KIRKLEES METROPOLITAN COUNCIL INVESTMENT & REGENERATION SERVICE

Reference No:	2025/62/92318/W
Site Address:	17, Clare Hill, Huddersfield, HD1 5BS
Description:	Change of use and alterations to dwelling to form 6 bedroom house in multiple occupation (Listed Building)
Recommending Officer:	Edward Cheseldine

Officer Report

2025/92318 - 17, Clare Hill, Huddersfield, HD1 5BS

Drawing Title:
PROPOSED FRONT AND REAR
ELEVATION AND FLOOR PLAN.

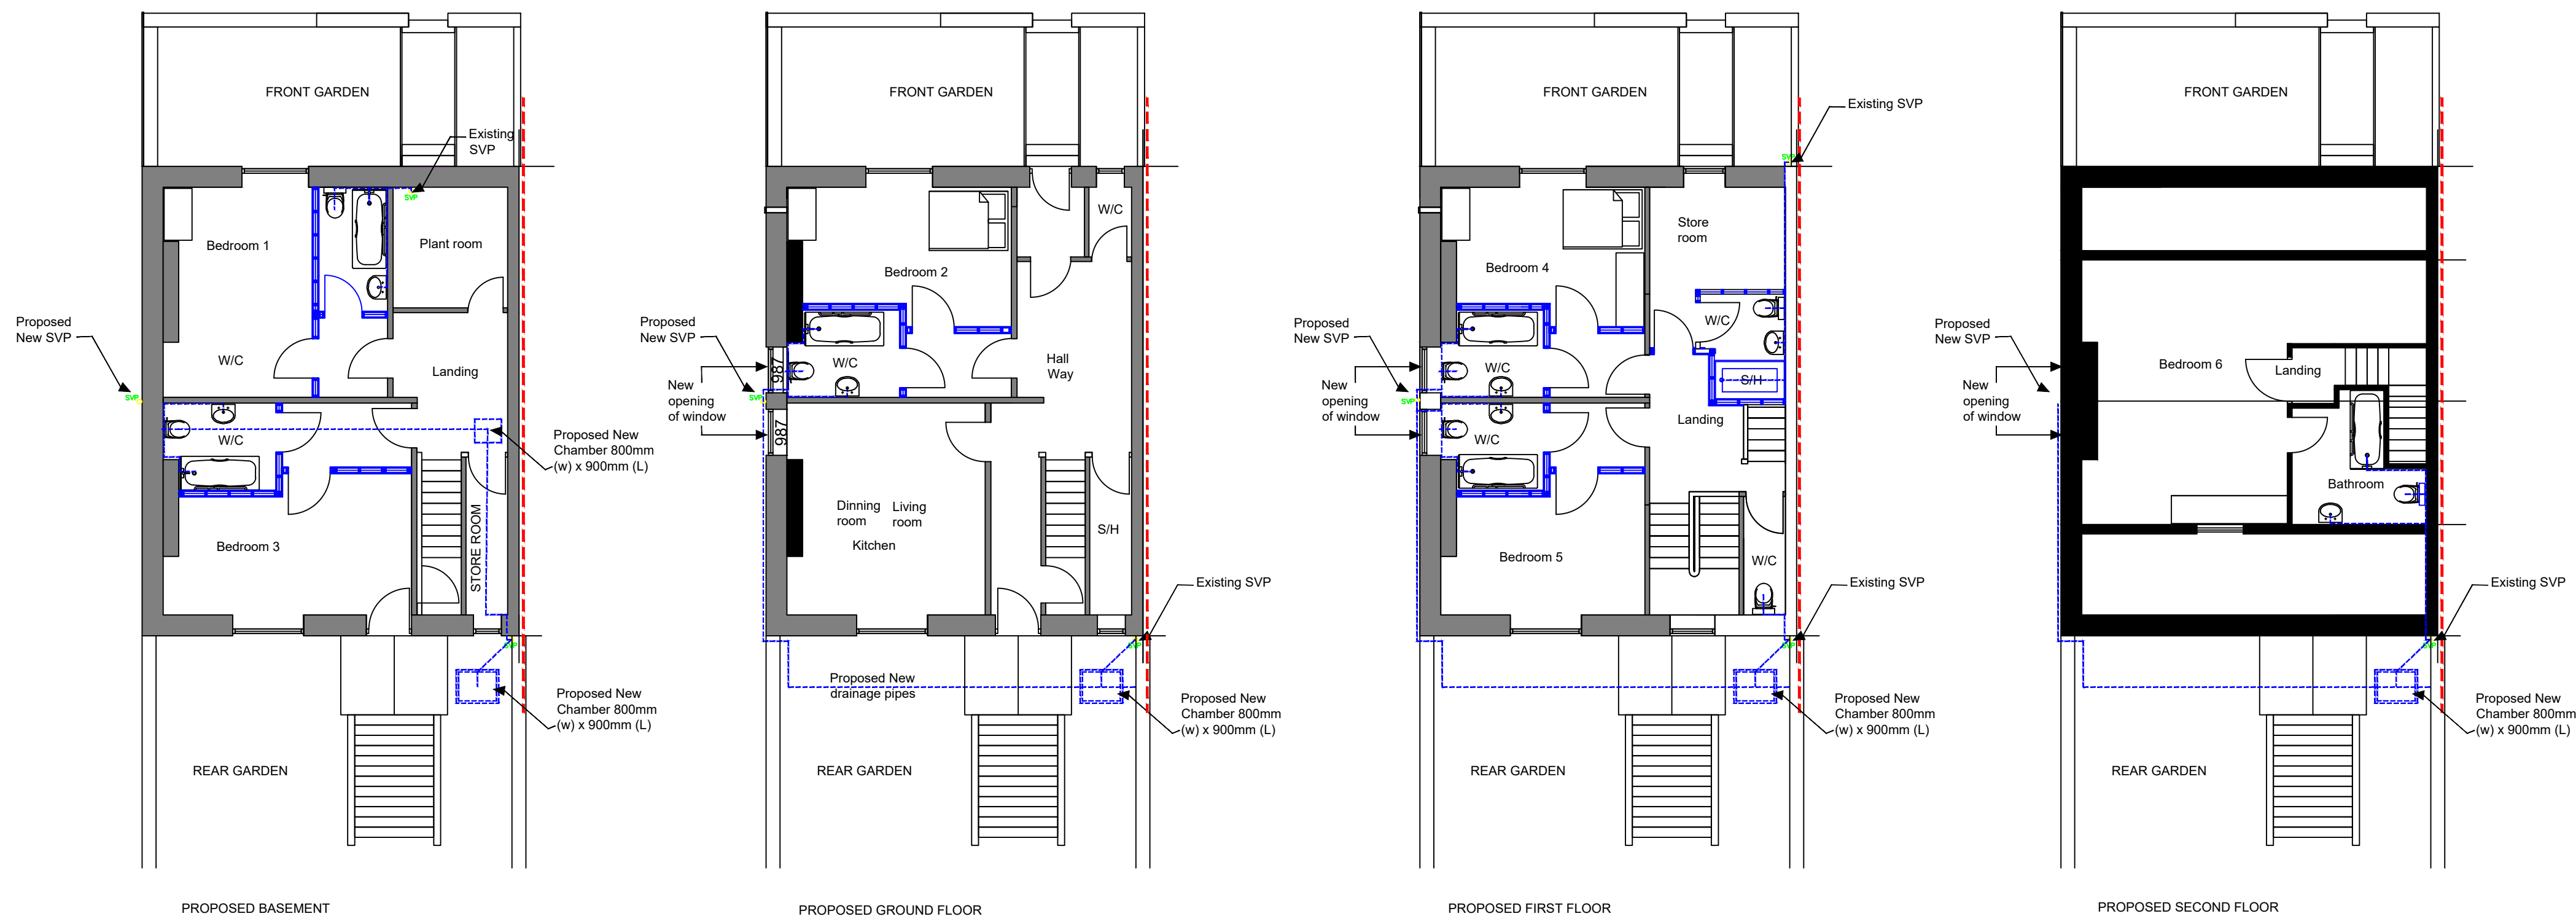
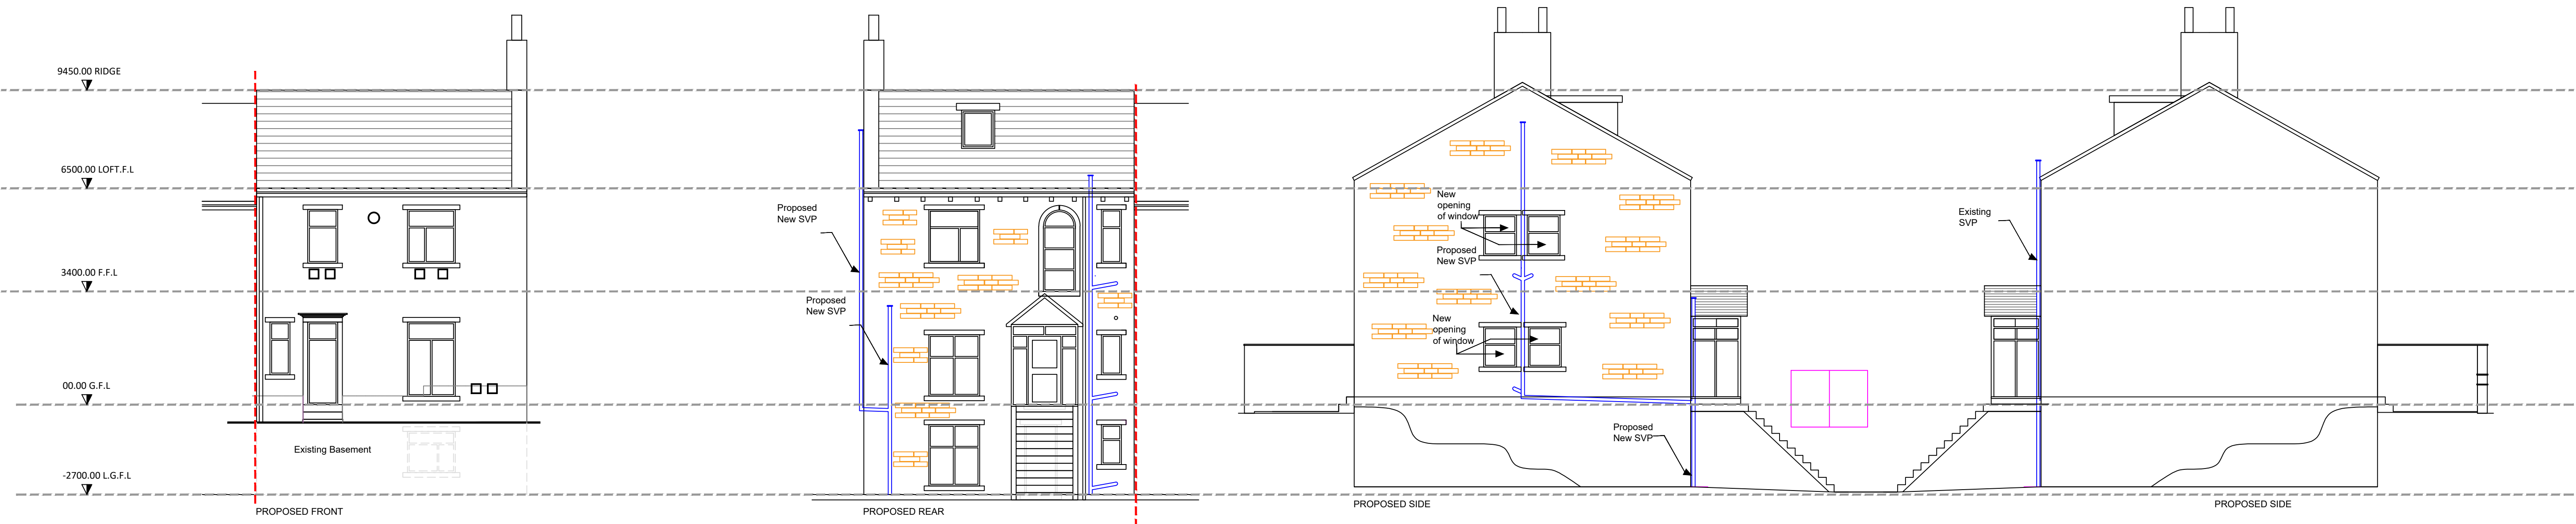
Officers requested a bedroom on the first-floor of the dwelling was removed from the scheme for use as a bedroom as the floorspace requirements of the bedroom were too small to accommodate a suitable living space. An amendment was received demonstrating this room would be used for storage and the application is processed on this basis.

Submitted plans indicate four new outlooks will be formed on the side elevation on the ground and first-floor. Three of these openings light bathroom areas. In terms of these, in order to protect the amenity of future and neighbouring occupants it will be conditioned they are obscurely glazed, if the application was set for an approval.

The fourth window light a dining room / living area. It is a secondary outlook with views towards the gable-end of the adjacent building, which are separated by a tall boundary wall. As the windows is primarily secondary, it is not considered it will impact upon the privacy of the neighbouring occupants.

- Bedroom 1 – 14m² (single occupancy)
- Bedroom 2 – 13m² (single occupancy)
- Bedroom 3 – 15.40m² (double occupancy)
- Bedroom 4 – 11.80m² (single occupancy)
- Bedroom 5 – 12.45m² (single occupancy)
- Bedroom 6 – 29.25m² (double occupancy)

The number of occupants within each room has been assessed against the floor space in each bedroom as per the standards set by Kirklees Council. Bedroom 3 & 4 would be considered to be at the minimum end of the scale, however they meet the floorspace requirements set out within Kirklees Council guidance. All rooms include an ensuite. The floor space of the ensuites would not amount to functionable space that could be utilised by a resident to accommodate amenity functions.
